Rezoning Transportation Analysis

Petition Number: 2022-210

Reviewer: Patrick Monroe
Patrick.Monroe@charlottenc.gov
704-301-1411

Revision Log:

RZ-03

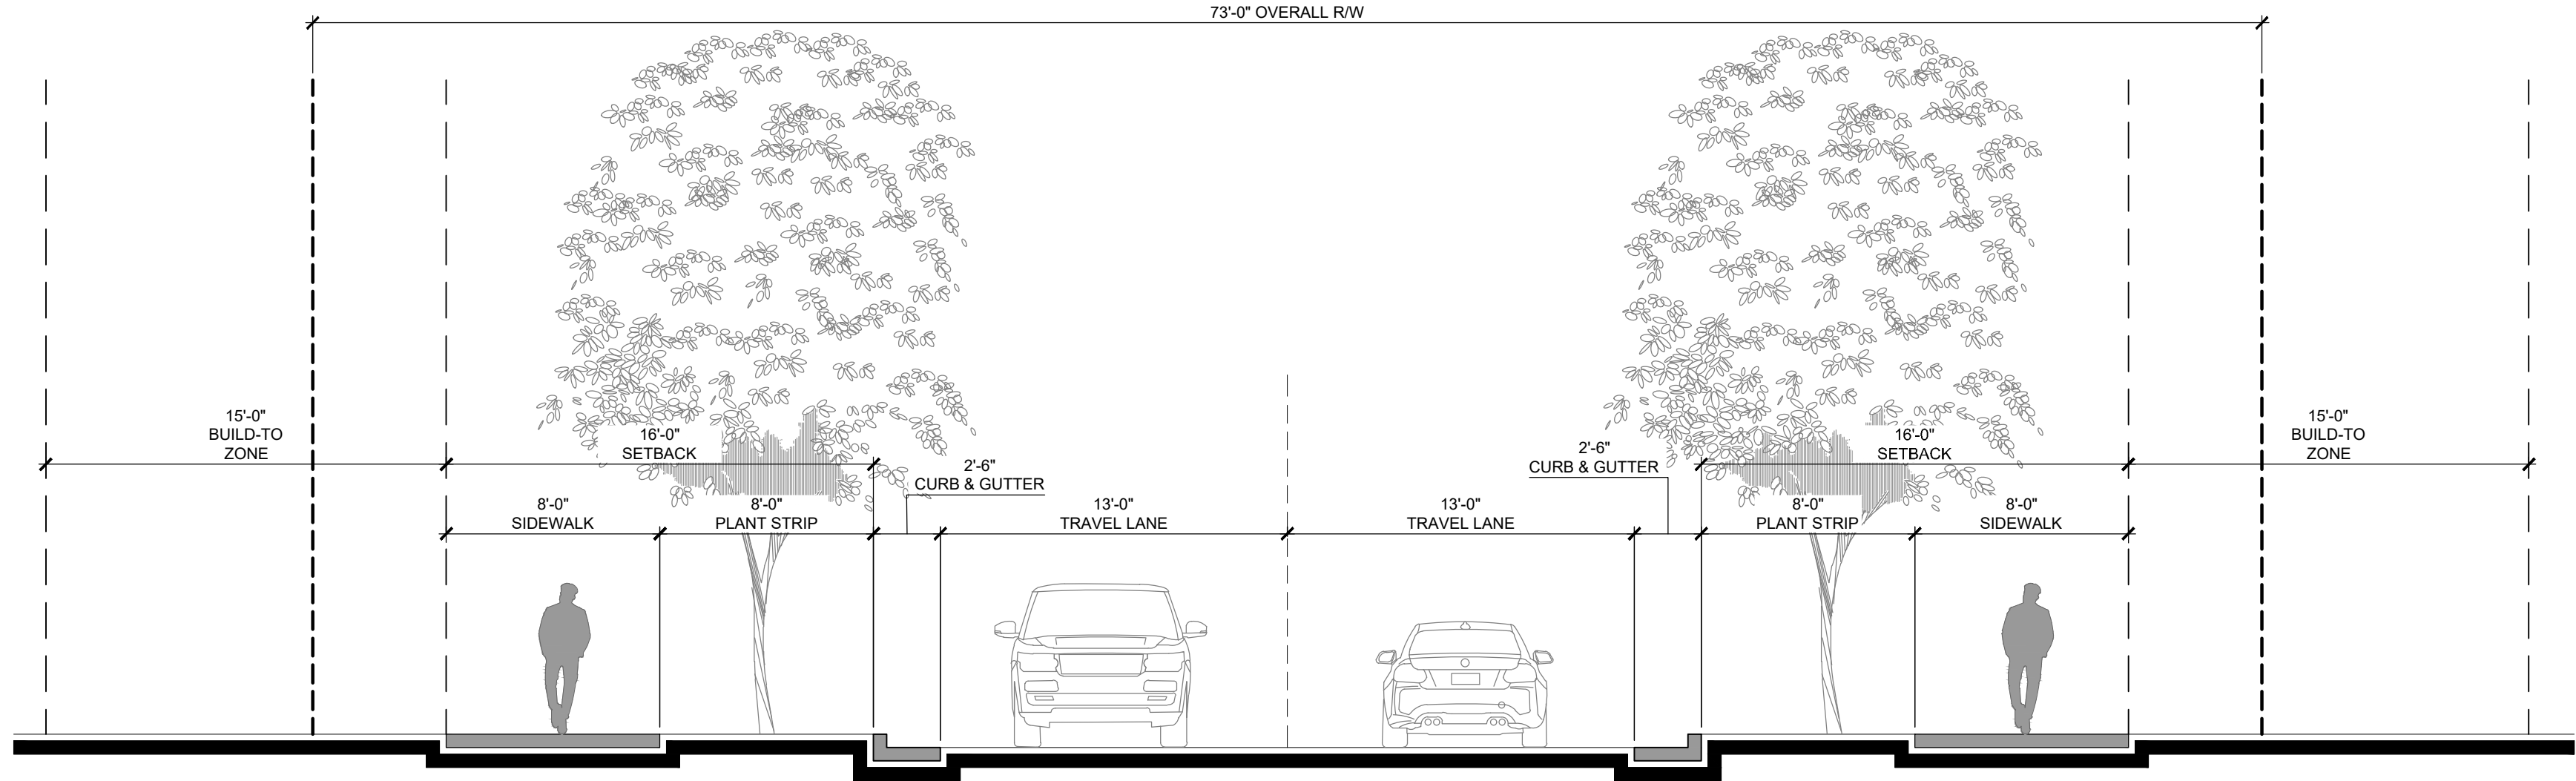
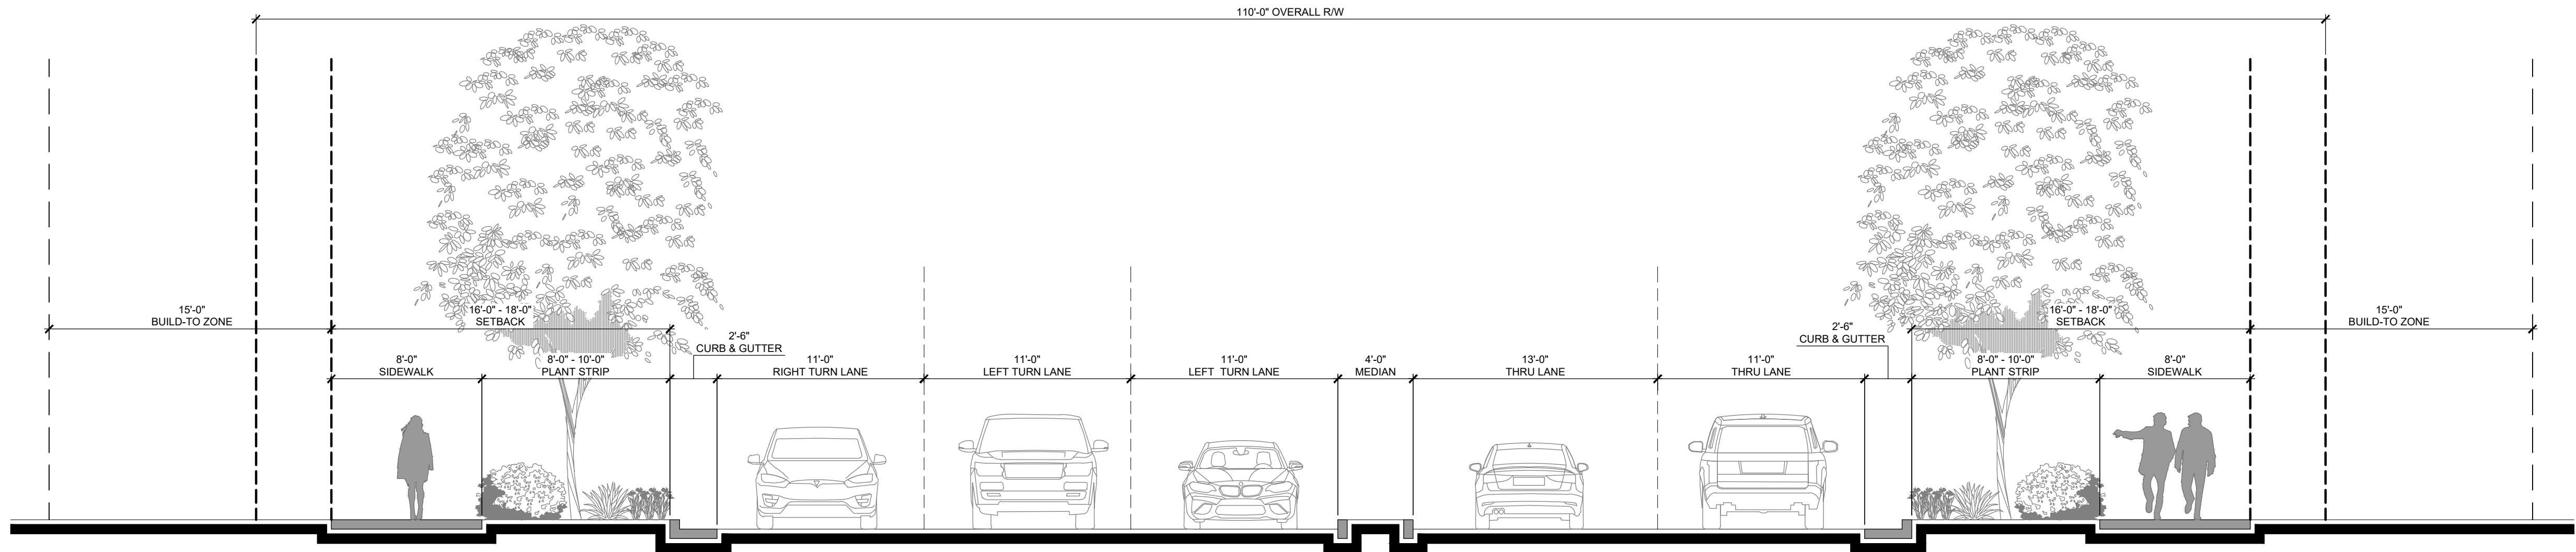
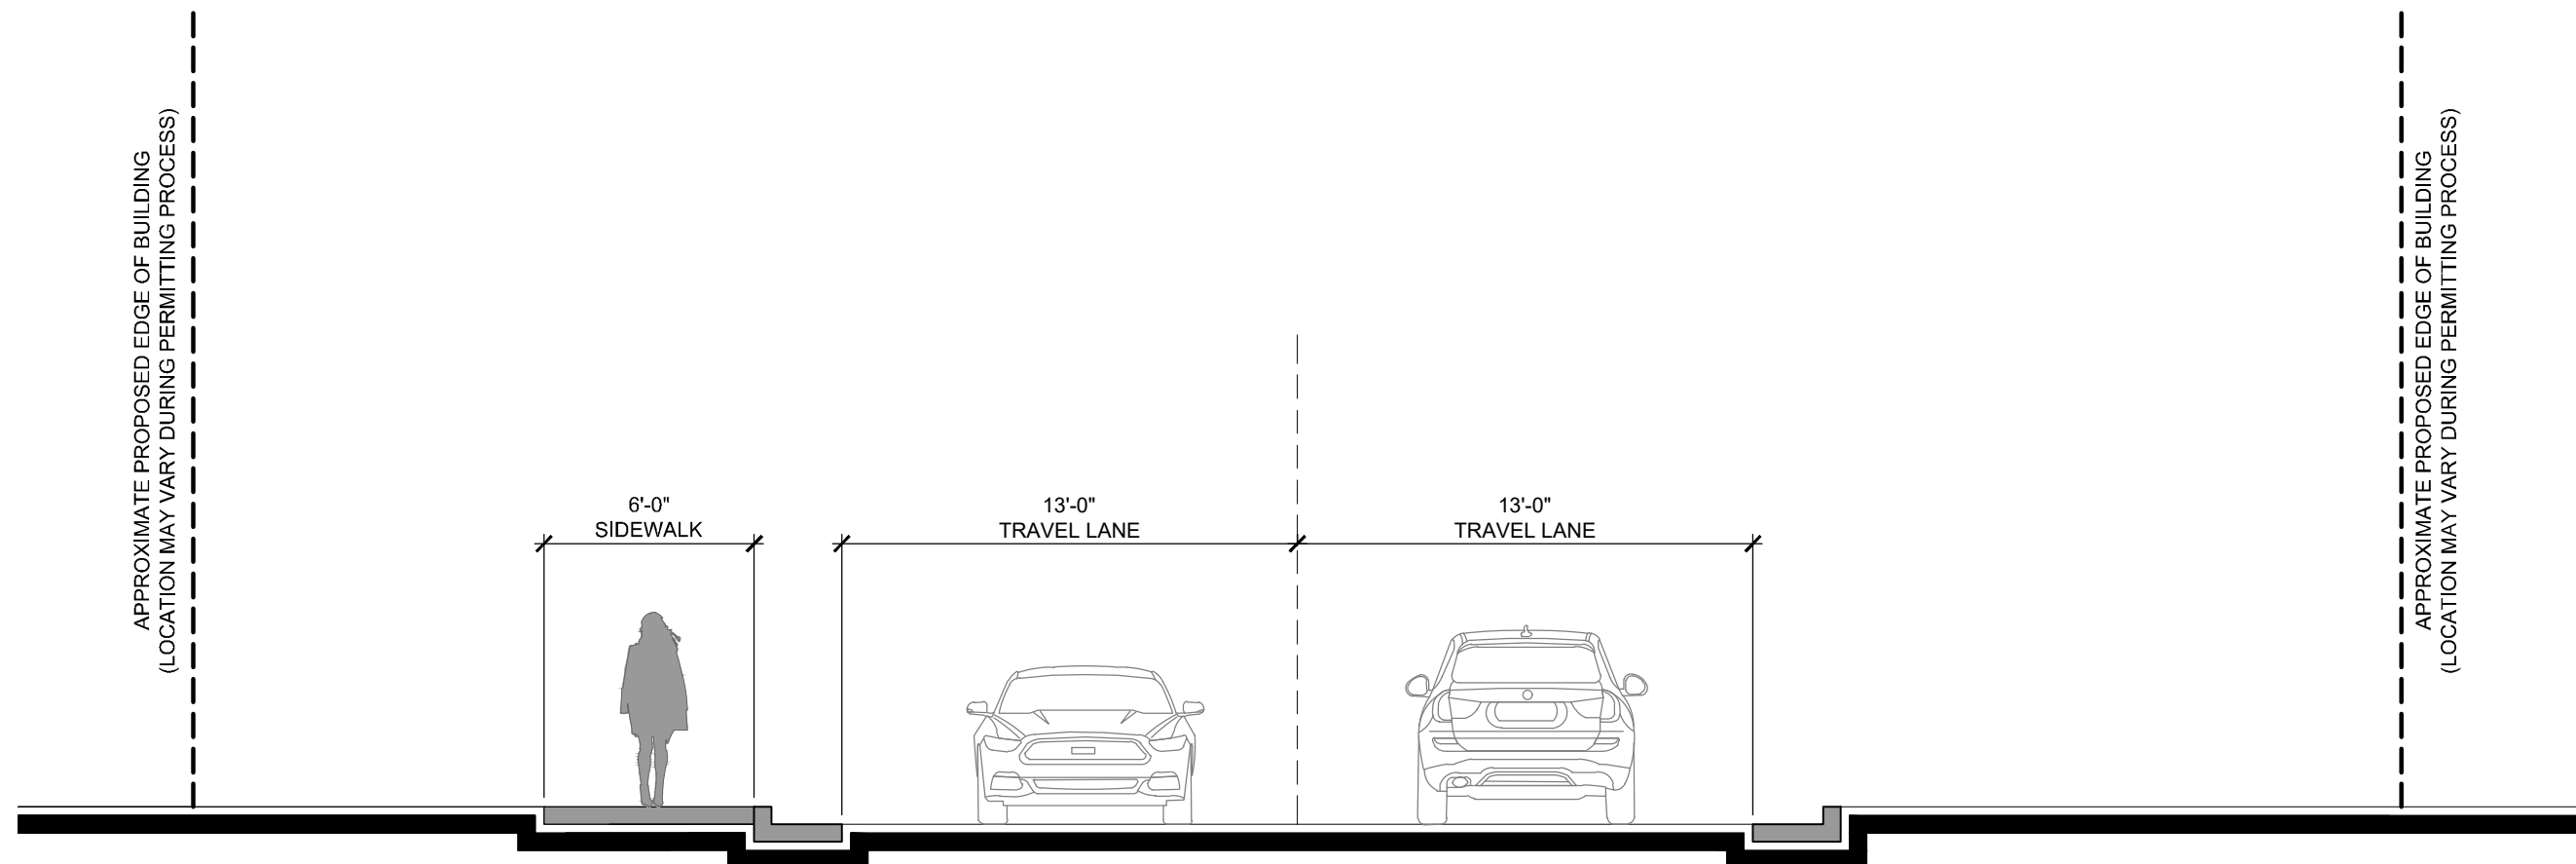
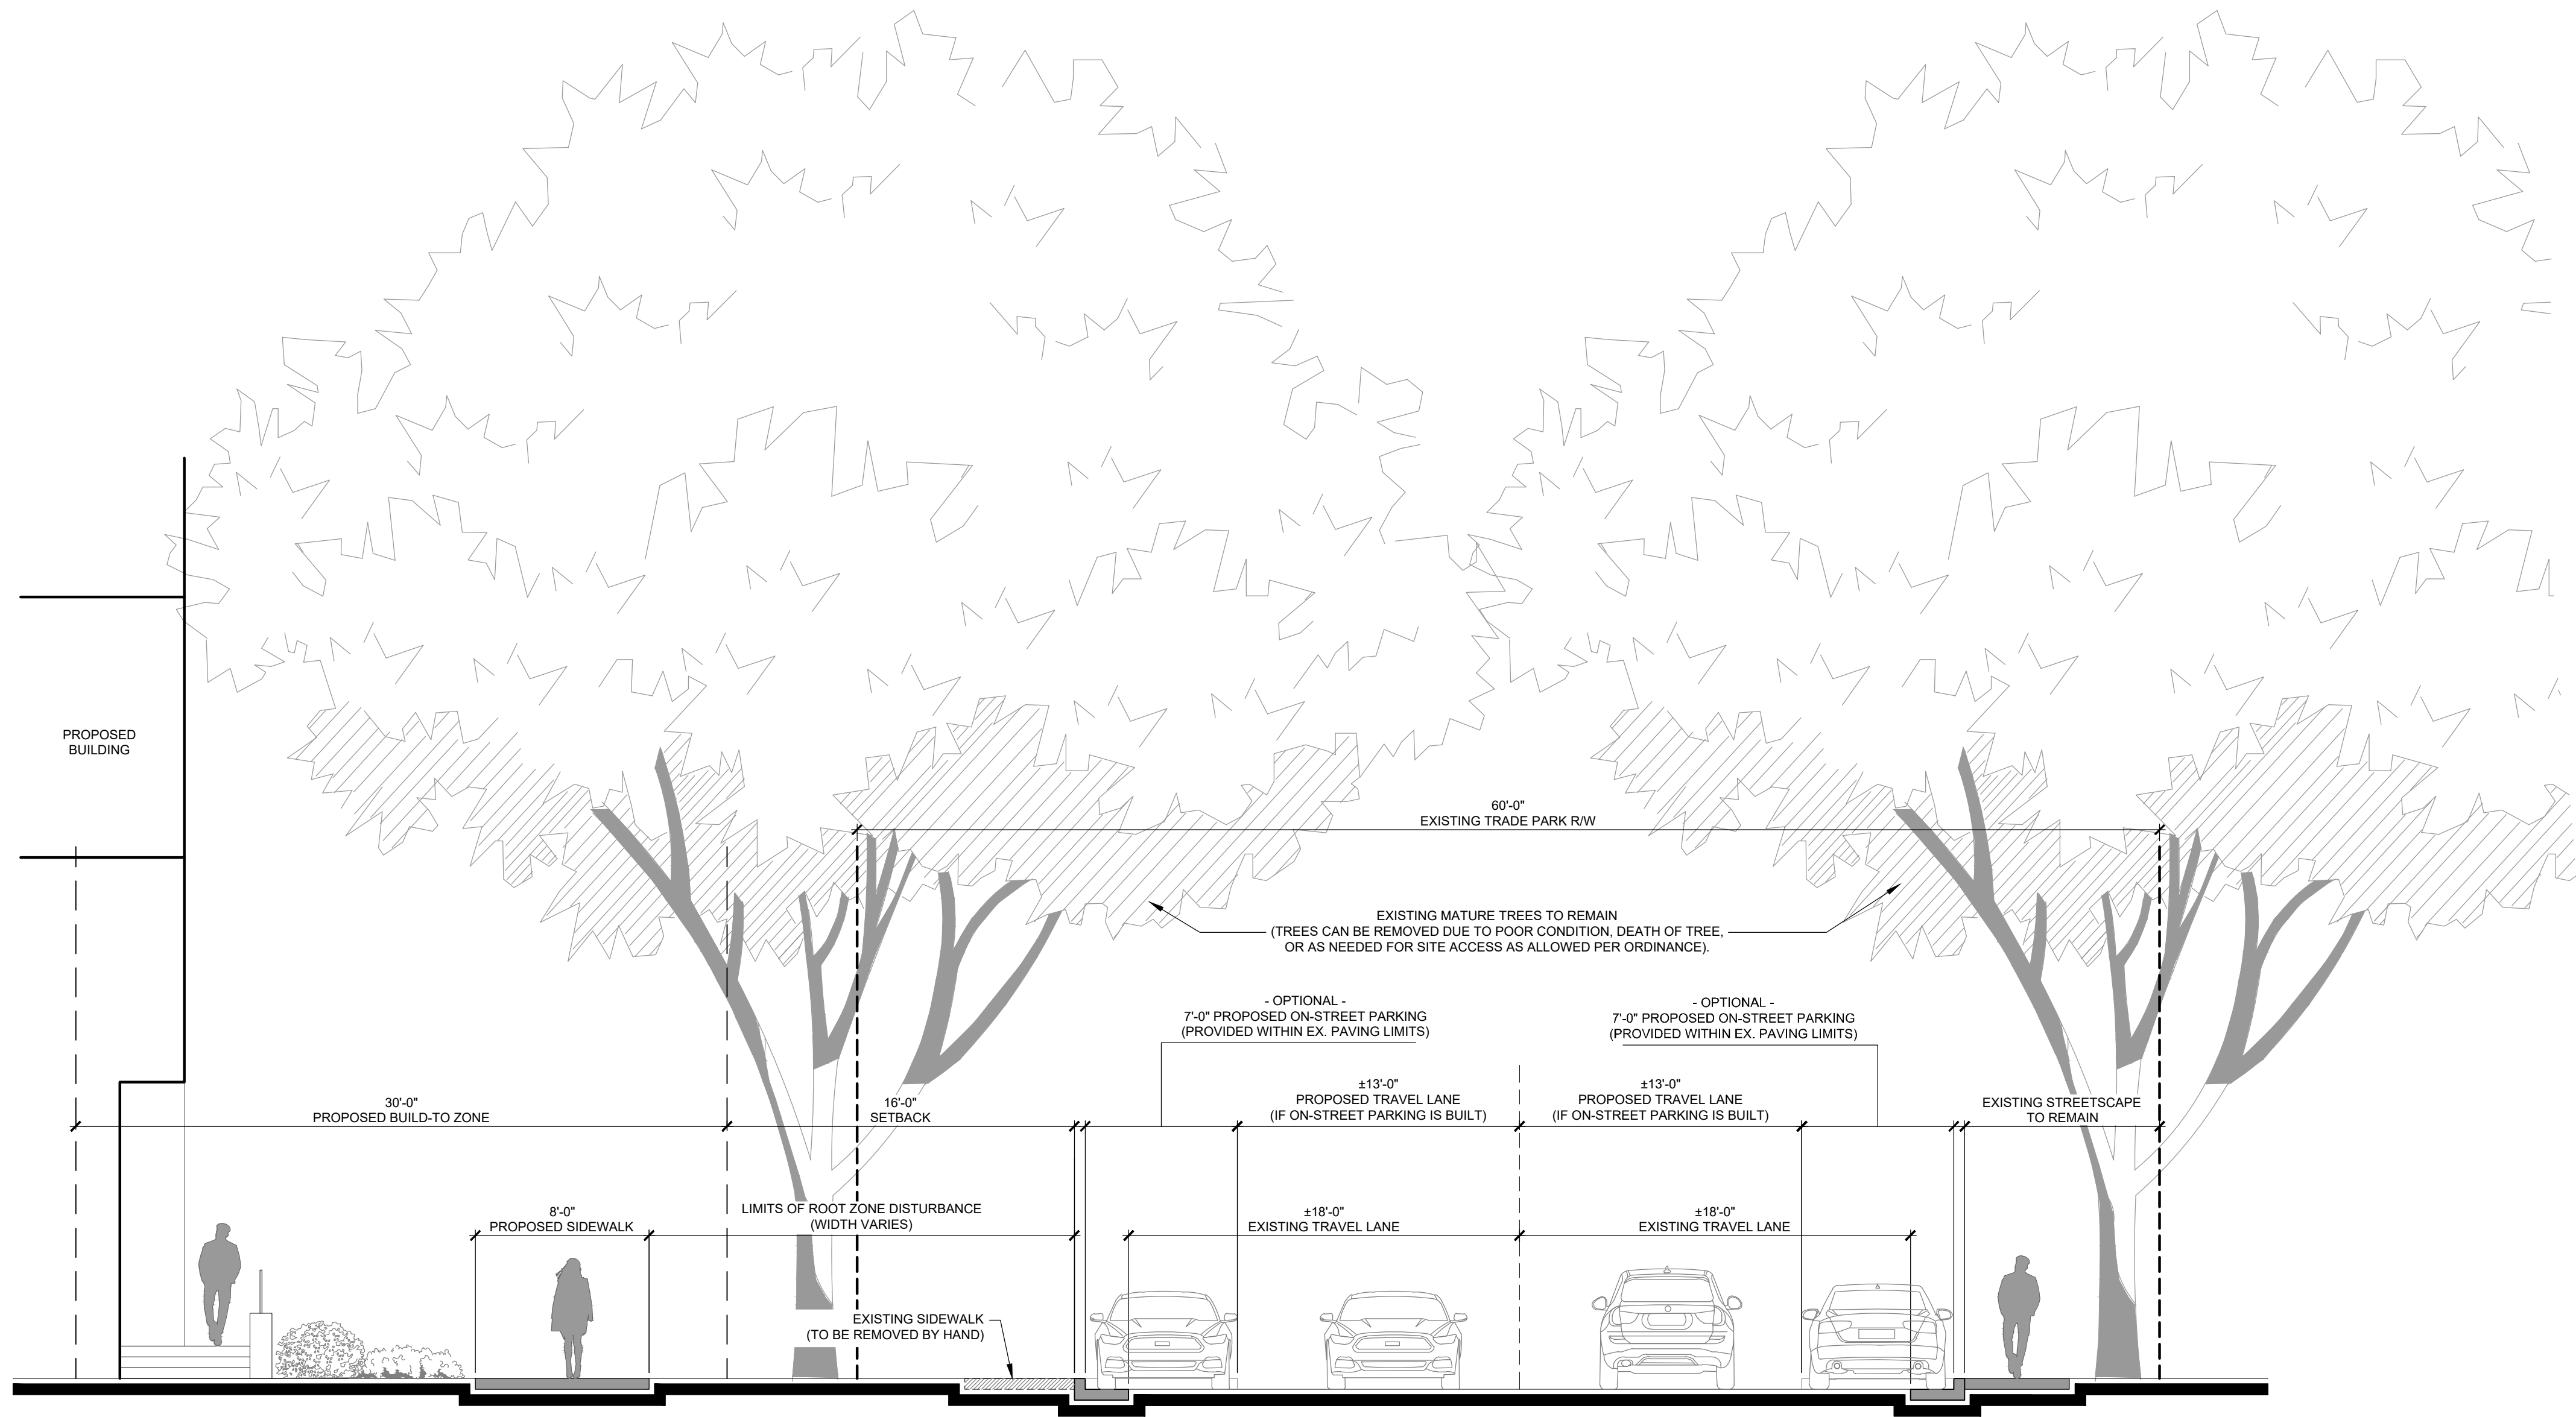
Outstanding Comment 9.20.23: Revise internal street network to standard public street typical sections per the CLDSM or provide additional information on existing constraints for review and approval of nonstandard typical sections.
